PROJECT NO. PR-2021-005482

Application No. SD-2022-00036

DESCRIPTION: Supplemental submittal addressing referral agency comments. Please refer to

**RE: PR-2021-005482: 2121 Yale Boulevard SE  
Design Review Board (DRB) – Supplemental Submittal Package**

PLAT OF
LOTS A THRU F
LOVELACE HEIGHTS ADDITION
 (BEING A REPLAT OF TRACTS A-1A, B-1 AND C-1, LOVELACE HEIGHTS ADDITION)

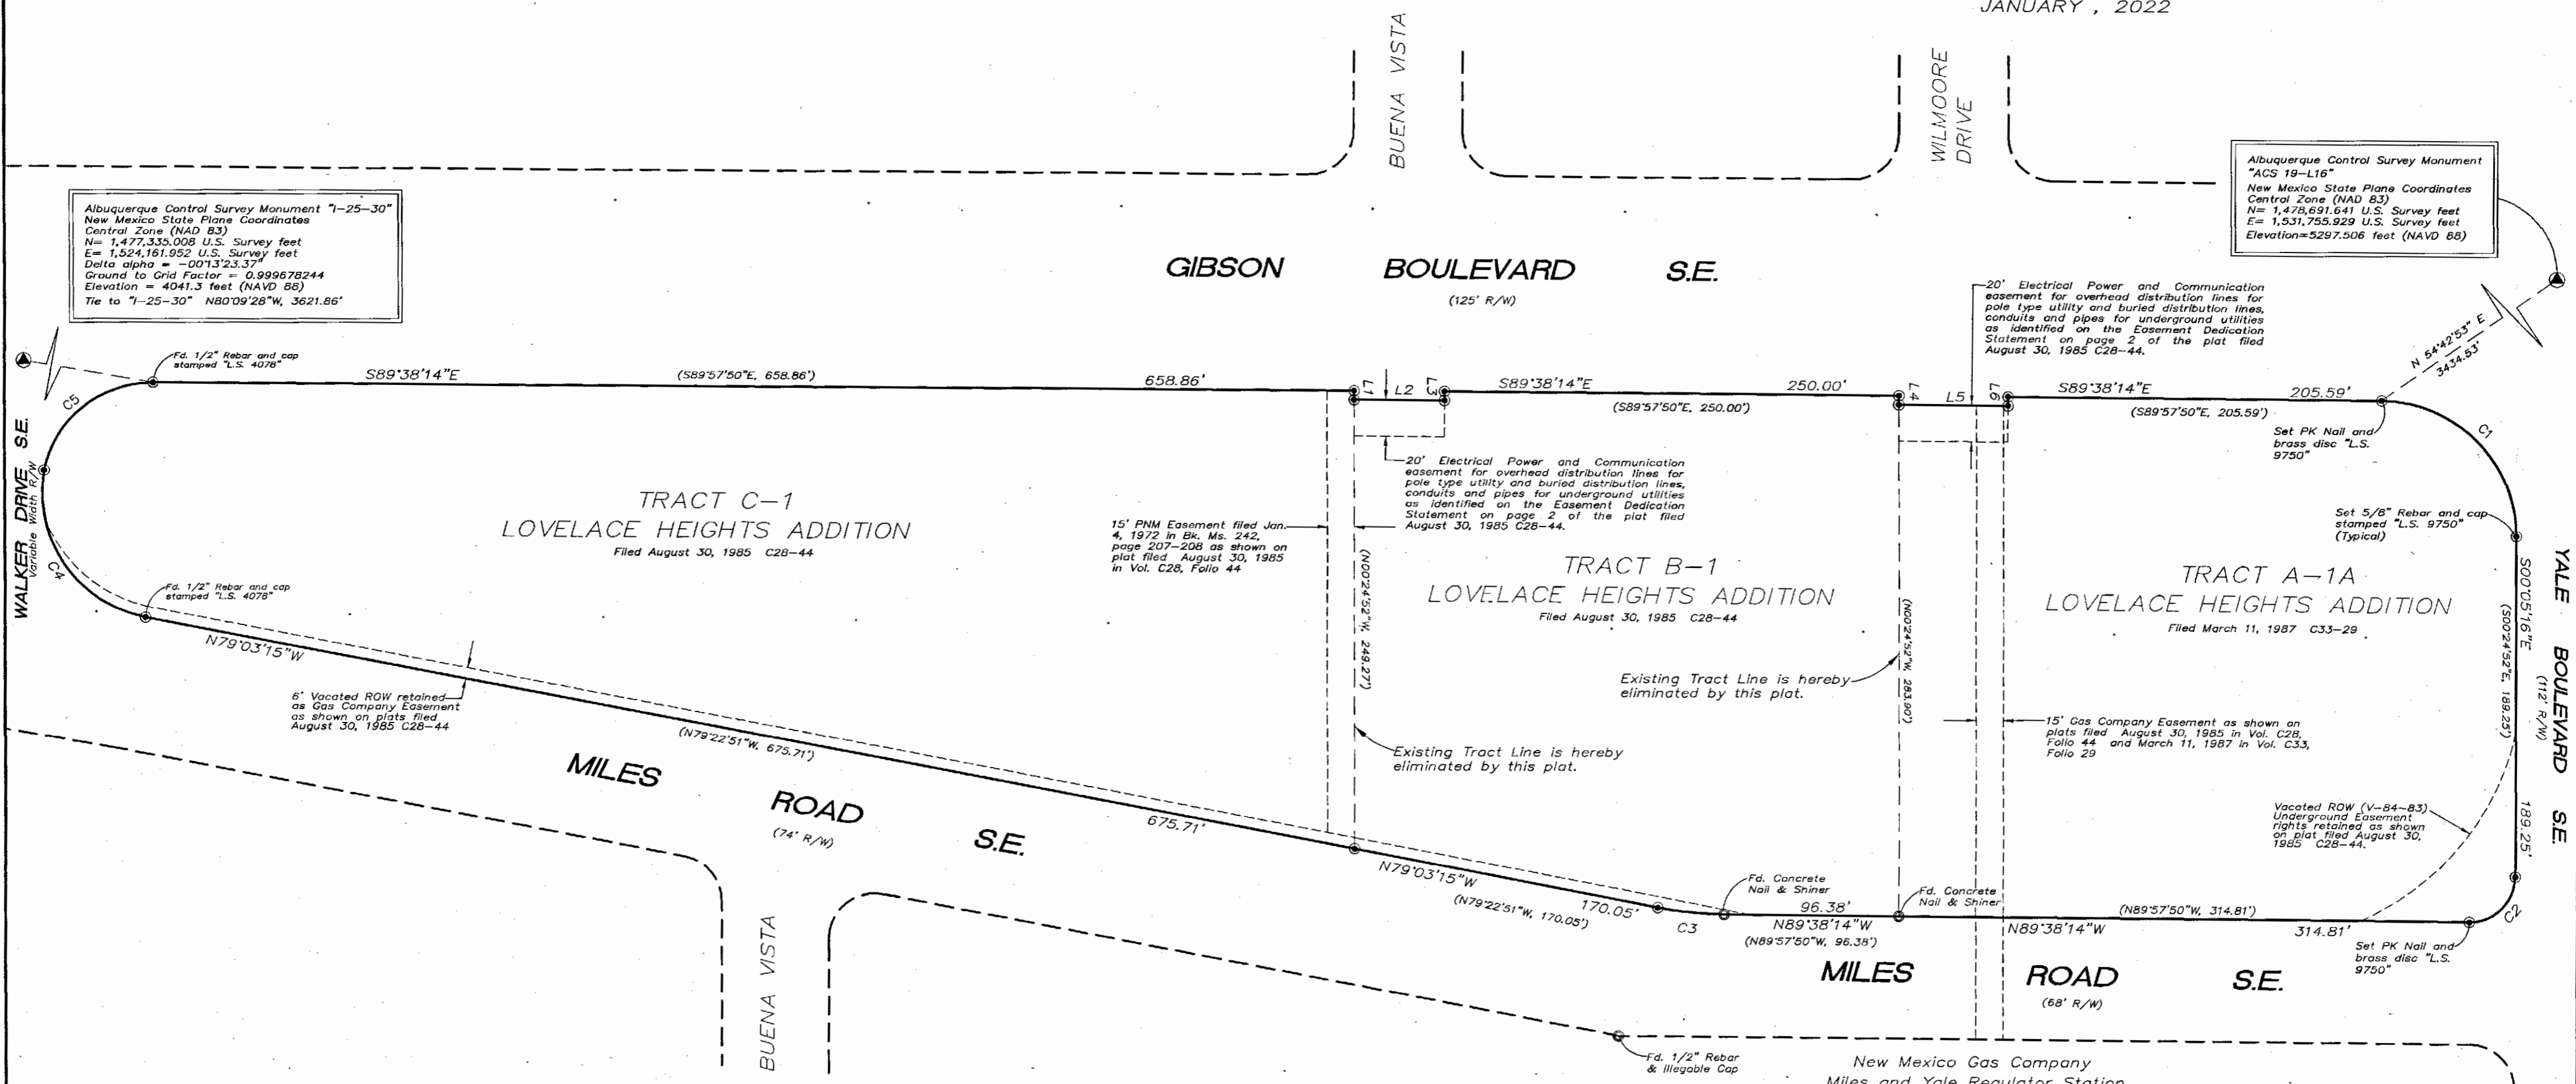
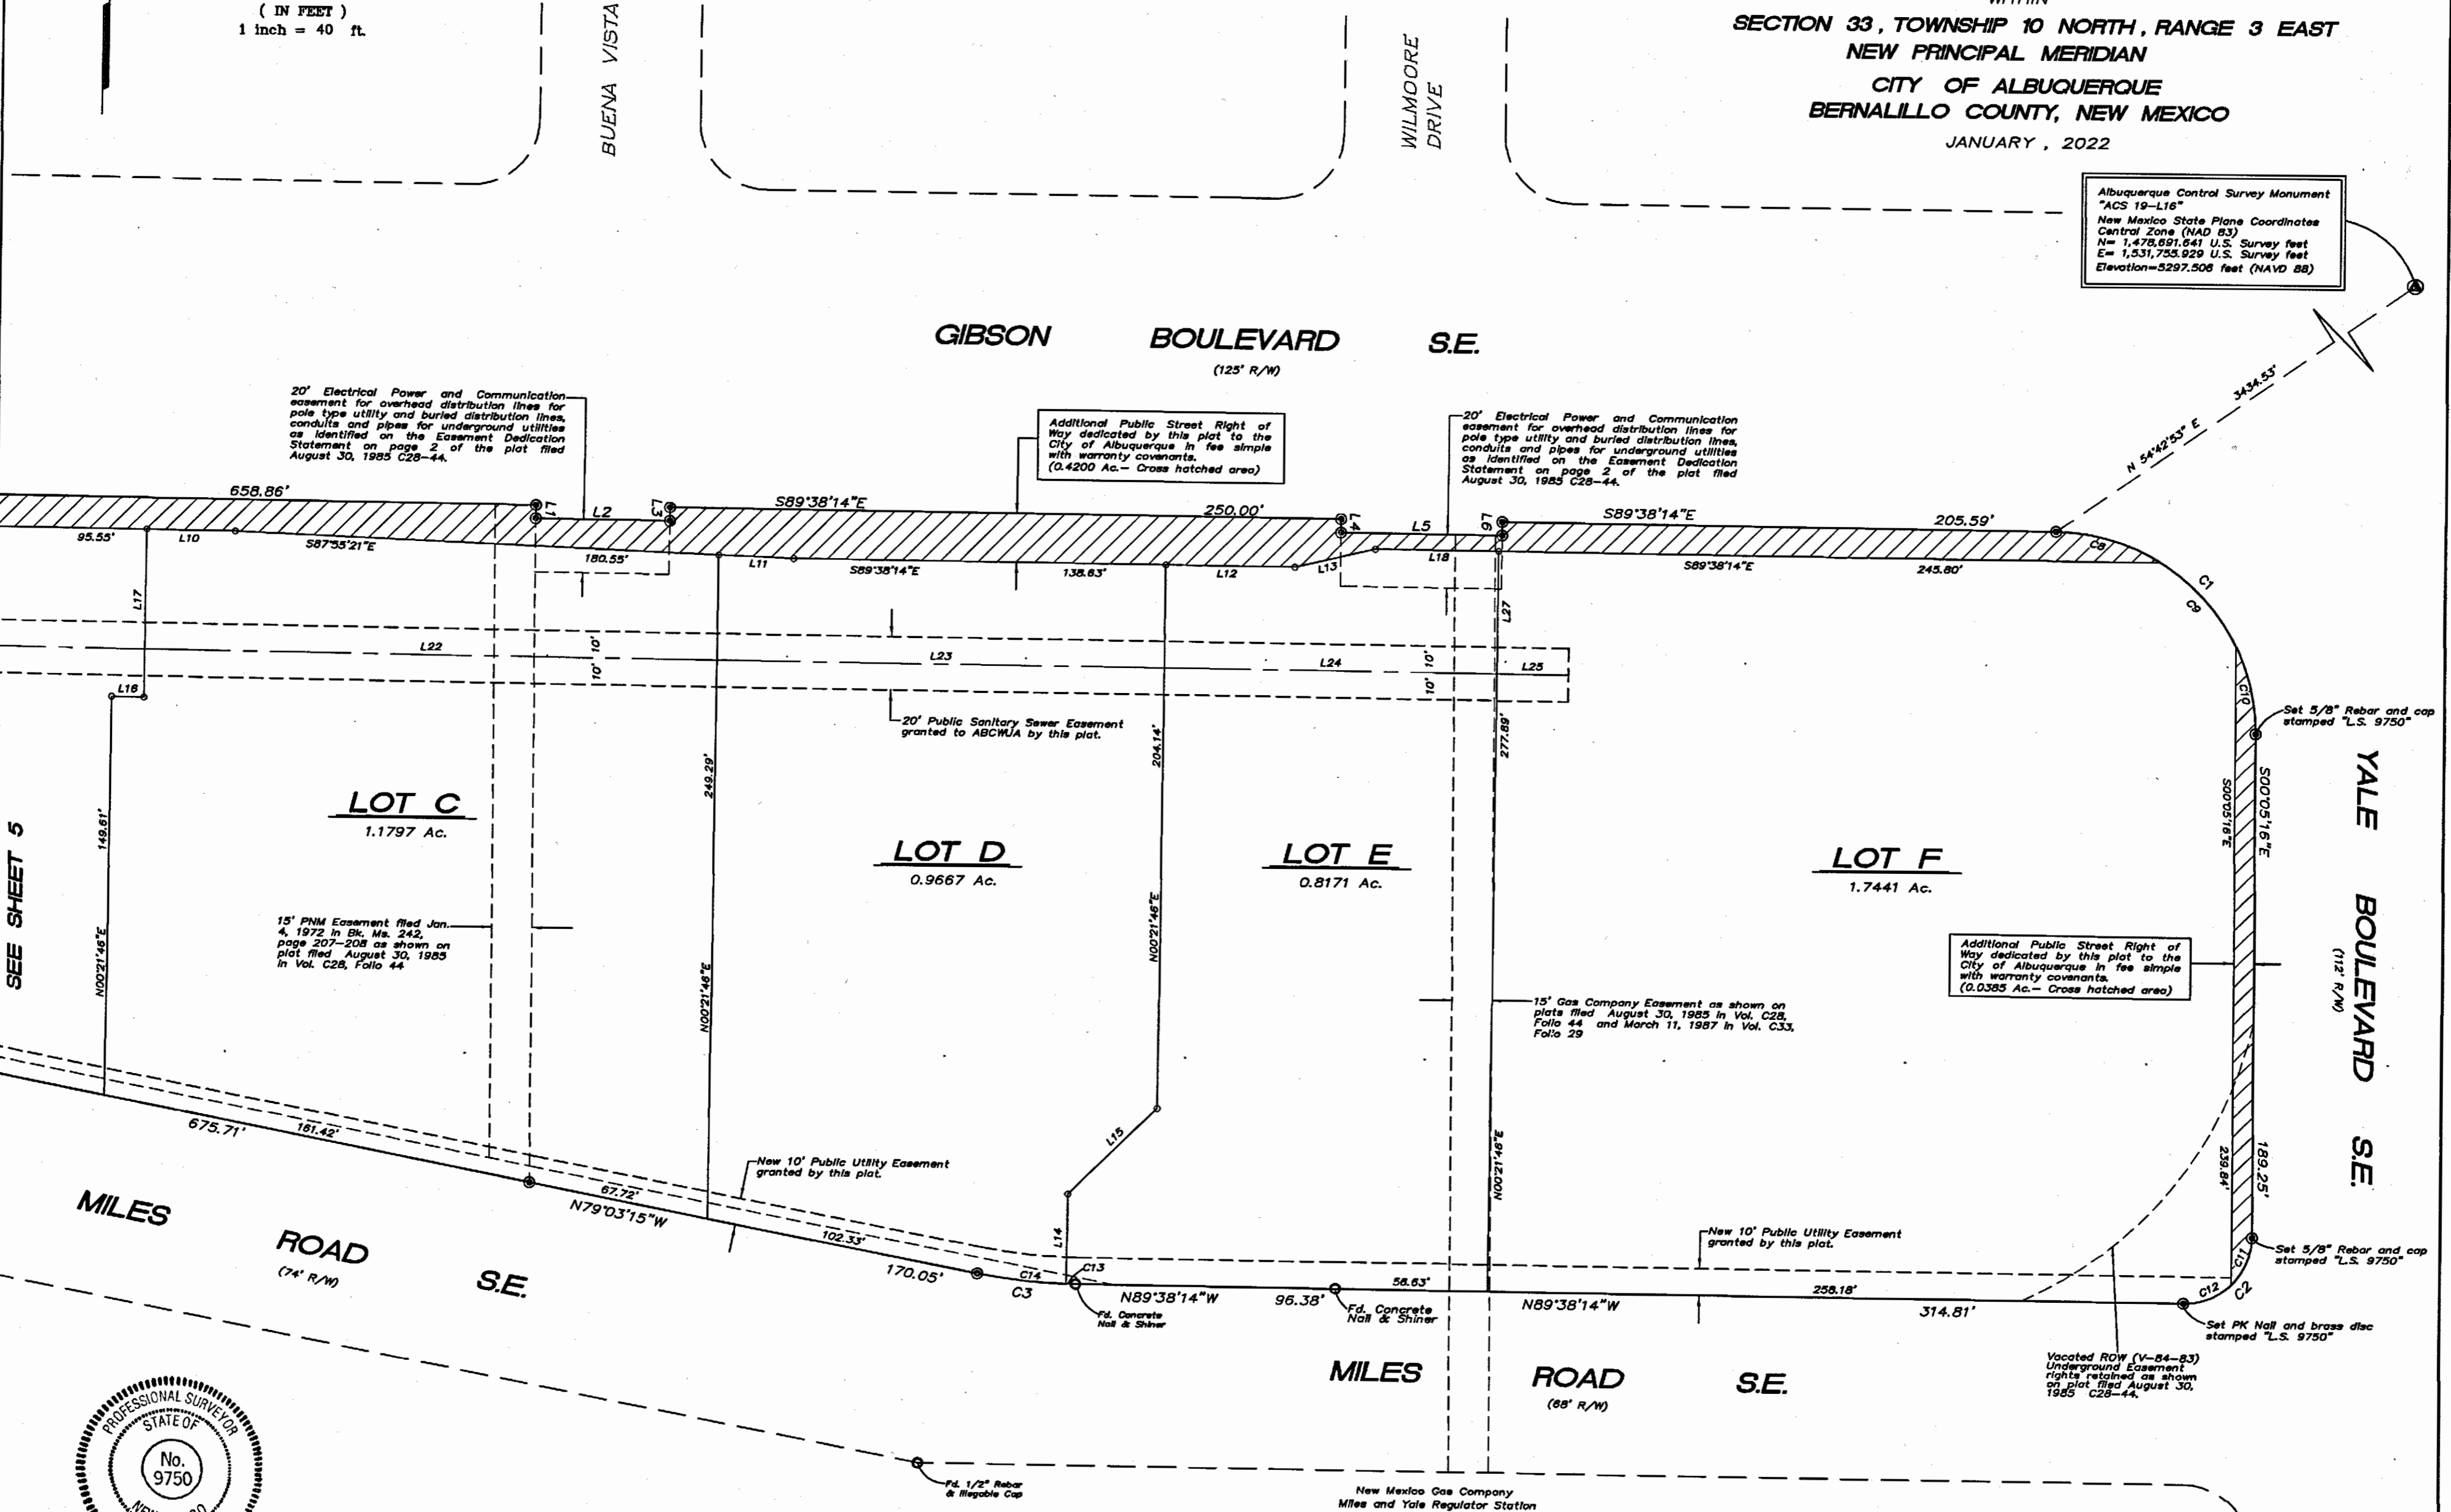
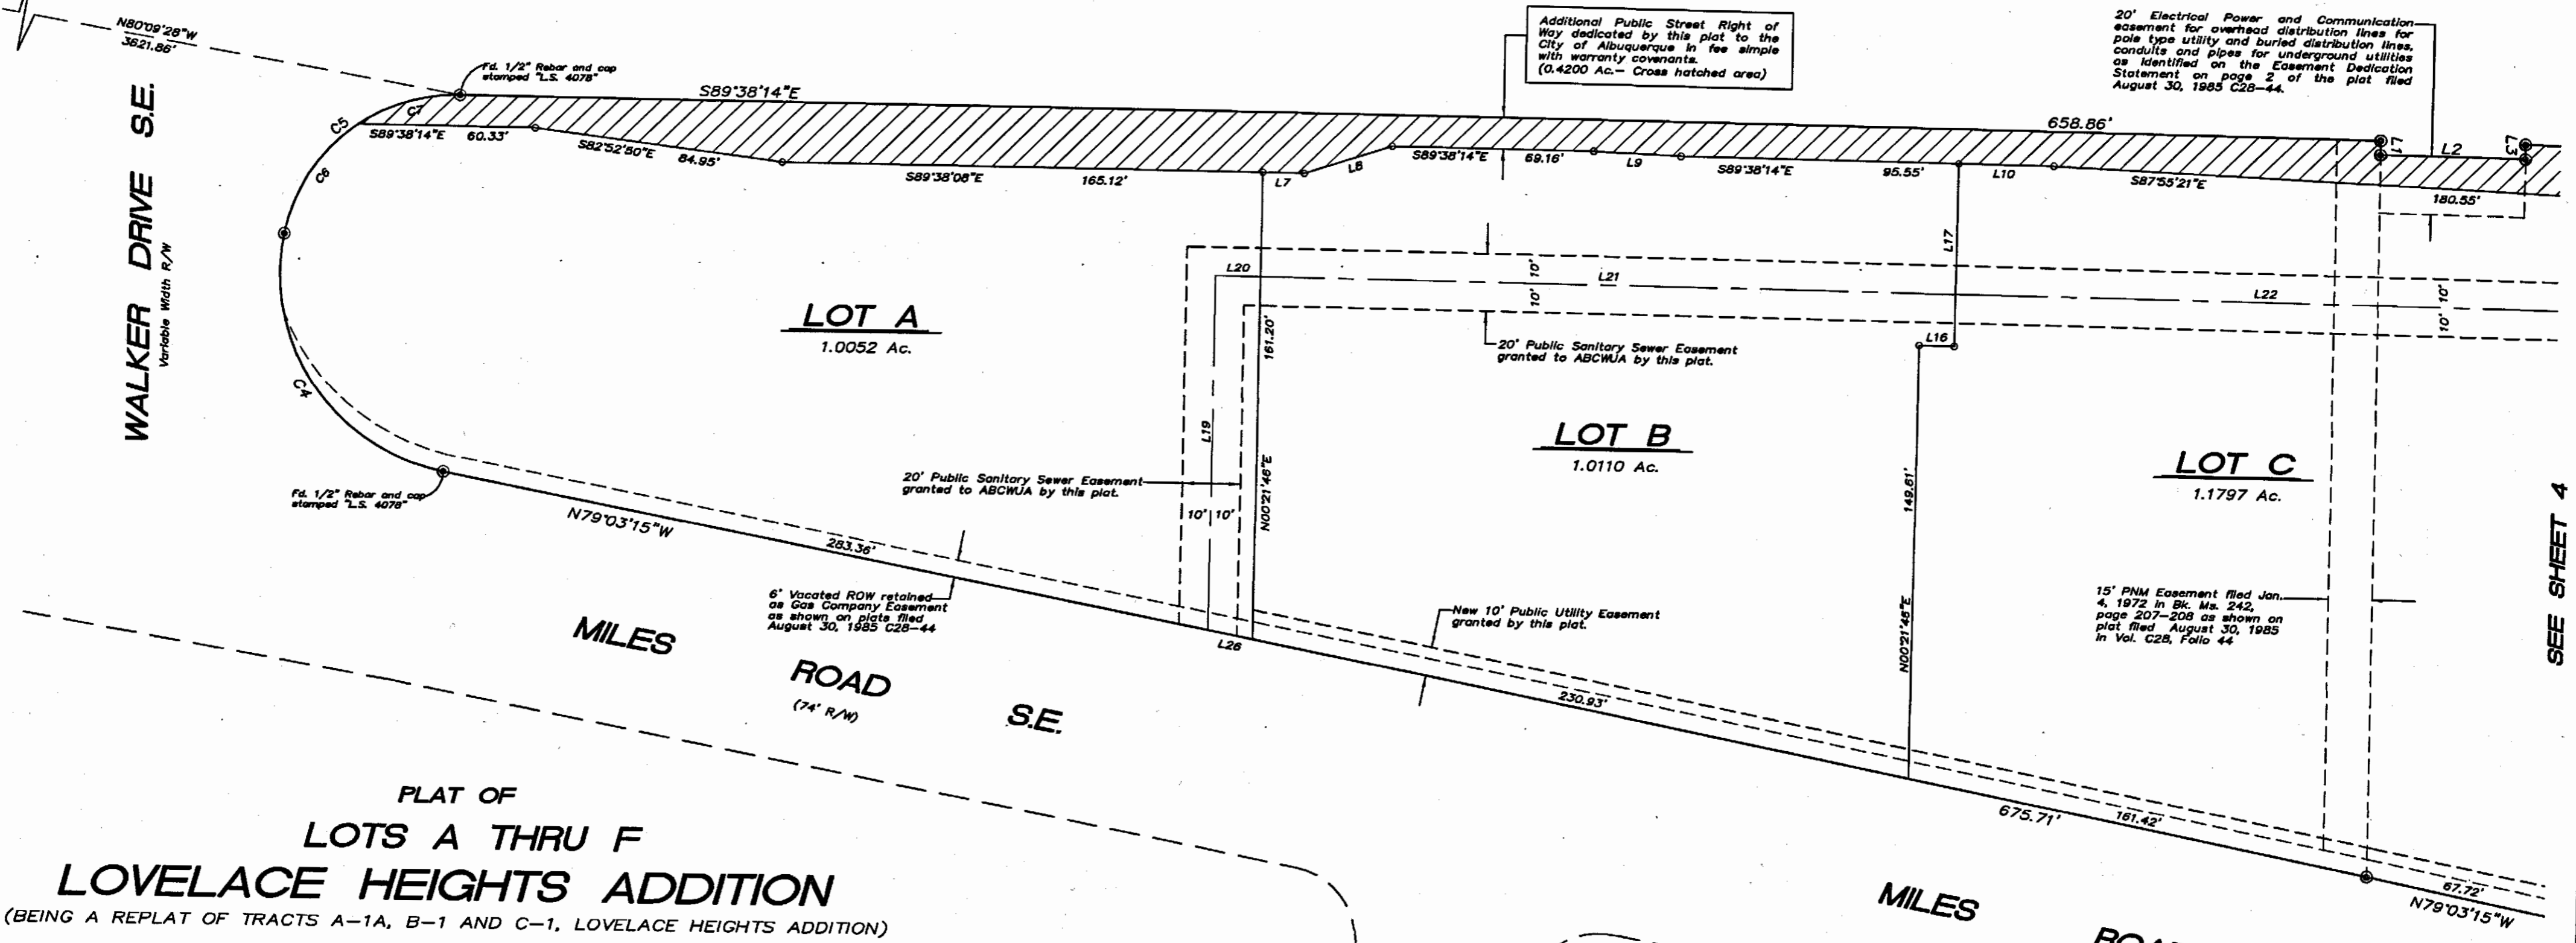
- Hydrology has an approved Conceptual Grading and Drainage (M15D021) with approval date of 1/6/22.  
**Galloway Response: Noted, thank you.**
- Please provide a cross lot drainage easements on the plat stating beneficiaries and maintenance responsibilities.  
**Galloway Response: Please refer to Note #8 of the Preliminary Plat document.**

- This property is outside the MRGCD's jurisdiction. Please remove the signature line and approval note from page 1.  
**Galloway Response: Noted, thank you.**
